Please ask for: Nicola Moore
Email: nicola.moore@arun.gov.uk
Telephone: Ext 37944
Our Ref: R/156/20/PL
Your Ref:
Date: 18th August 2020

Application for Planning Permission

Development: Extension and alteration of existing residential dwelling and subdivision to form 2no. two bedroom residential dwellings, together with formation of new vehicular access and entrance drive.
Location: 31 Albert Road Rustington BN16 3JT

DRAWING TITLE
PROPOSED SITE LAYOUT PLAN

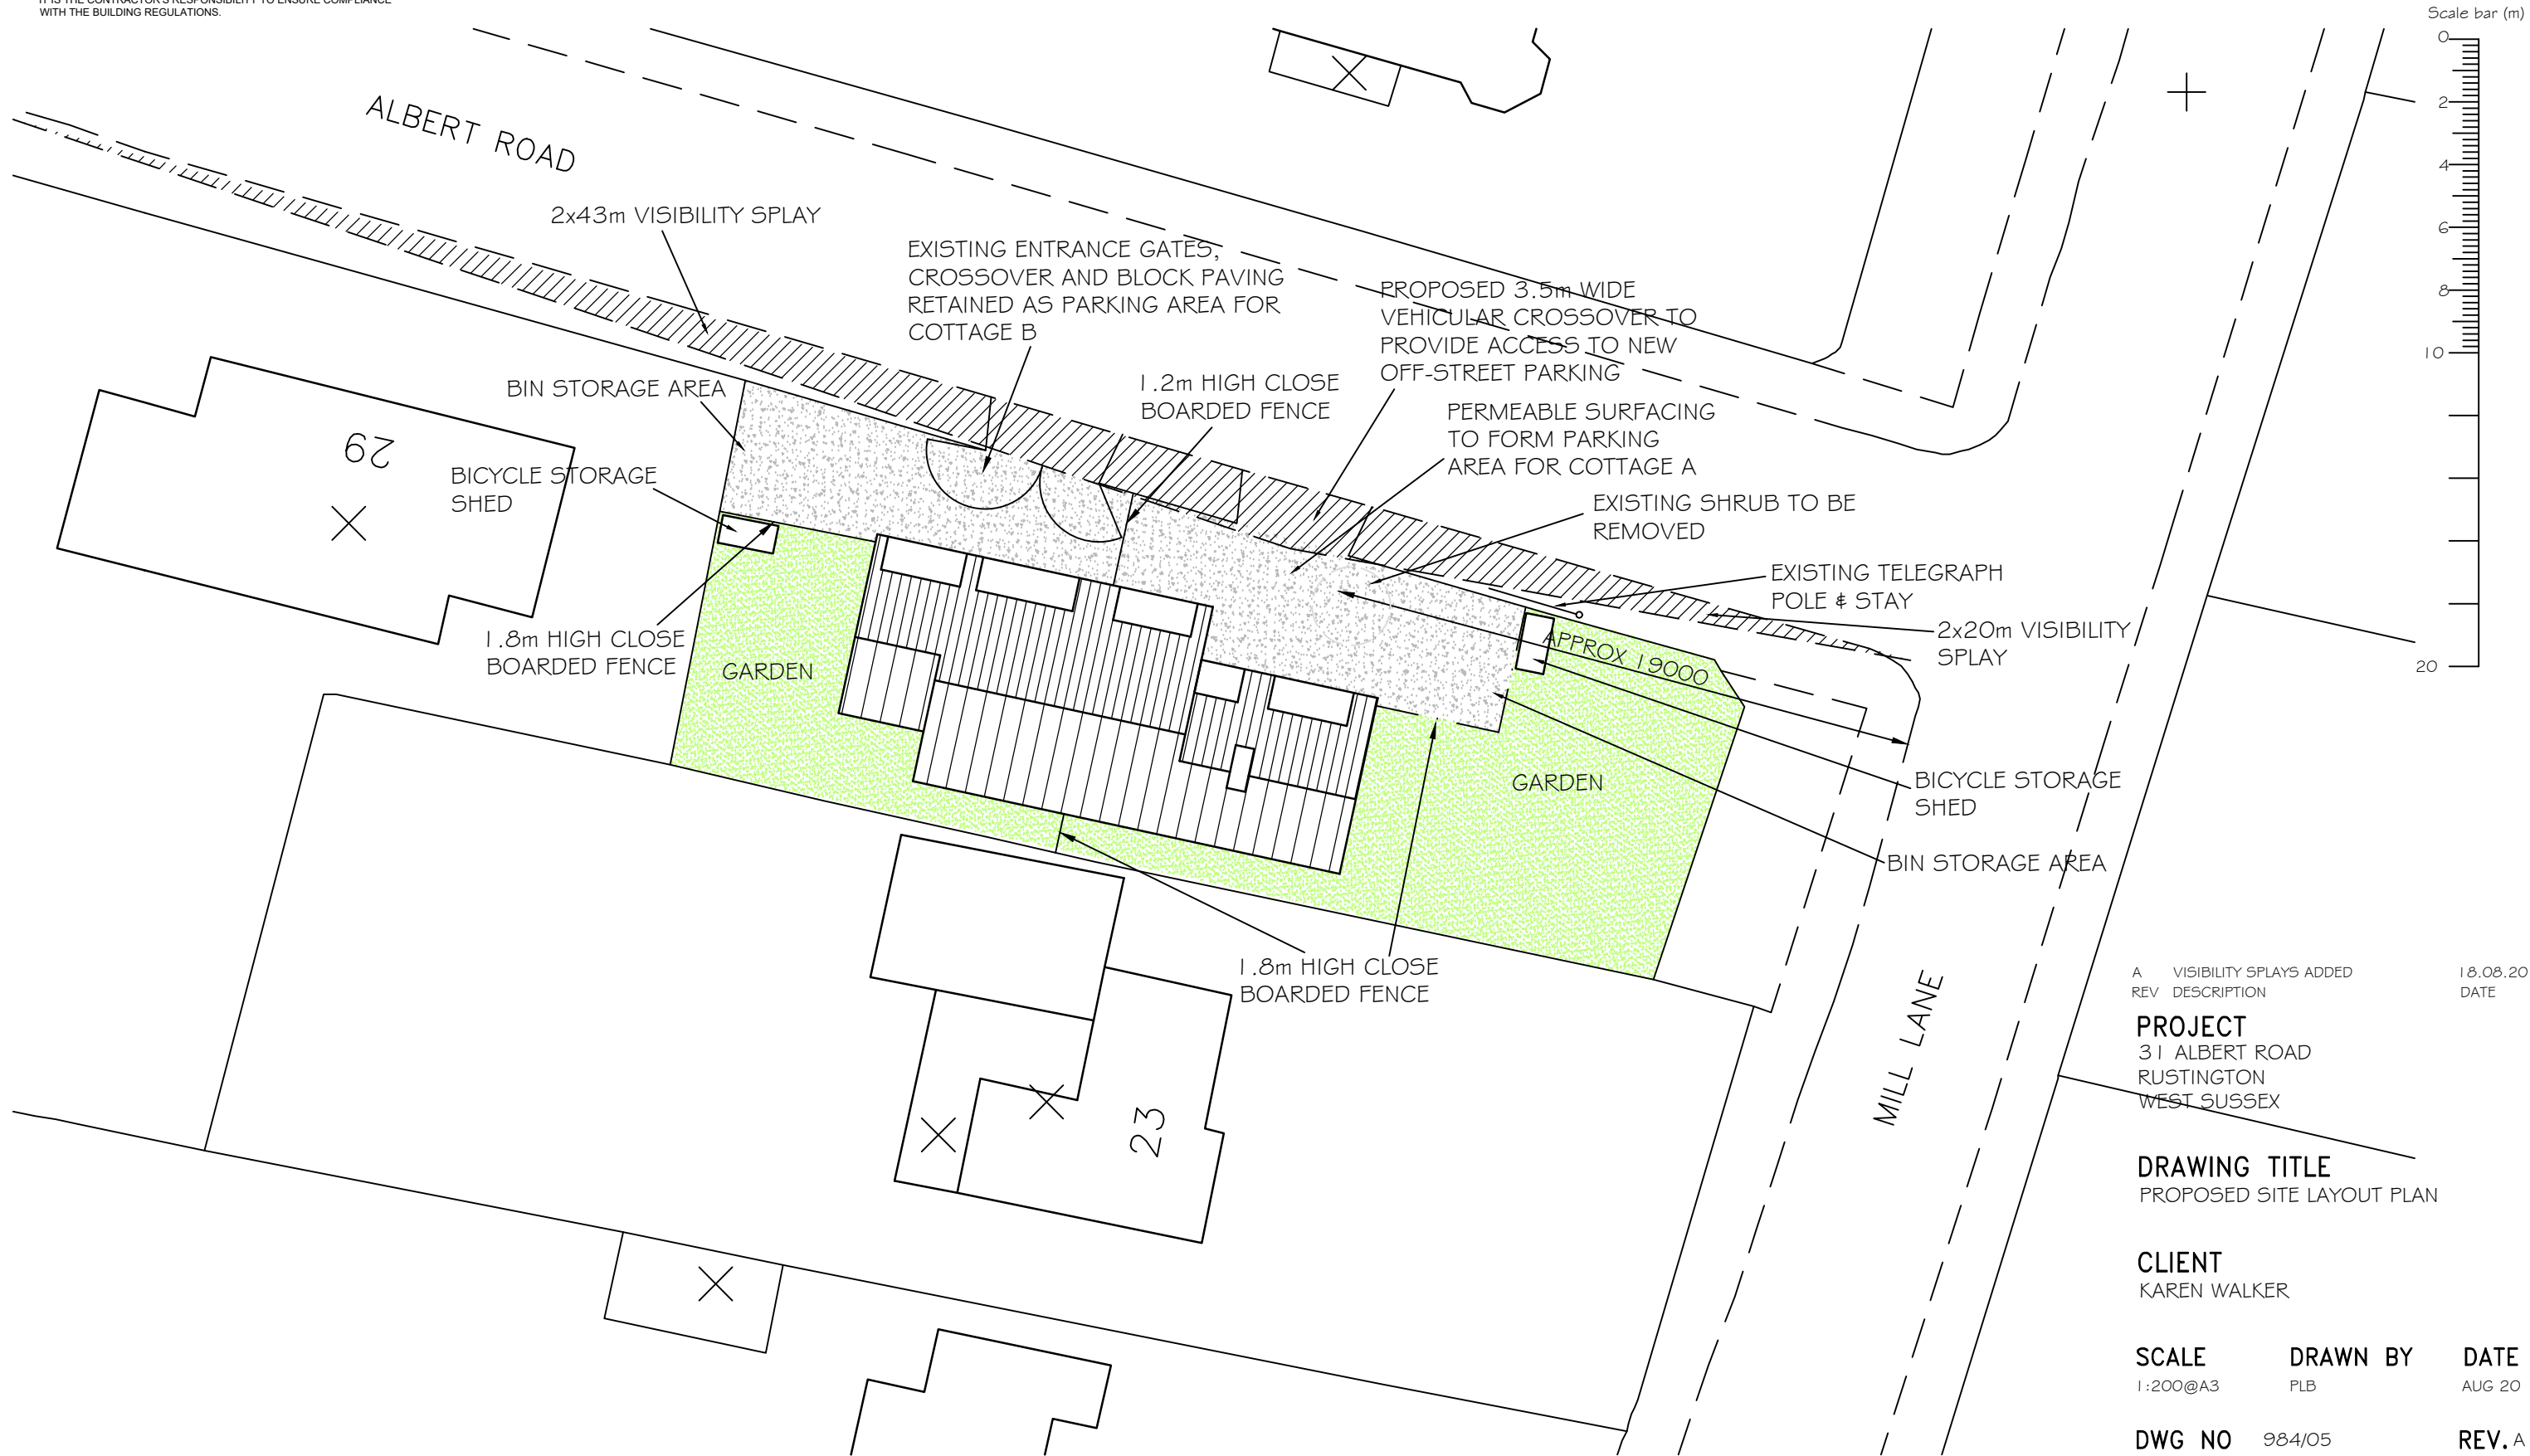
West Sussex County Council require that a visibility splay is provided. A splay is formed for a 30 mph speed limit road by measuring from a point 2.4m back from the kerb edge in the centre of the proposed access. A line should then be drawn from either side of this point for 43 m in each direction to the nearside edge of the carriage way. The splays must intersect land only within the control of the applicant, or within the publicly maintained highway.

The distance will increase with the speed limit of the road. If the road is 40 mph speed limit then the distance should be 120 m either side. For speeds above this please contact West Sussex County Council Highways for advice on what would be acceptable.
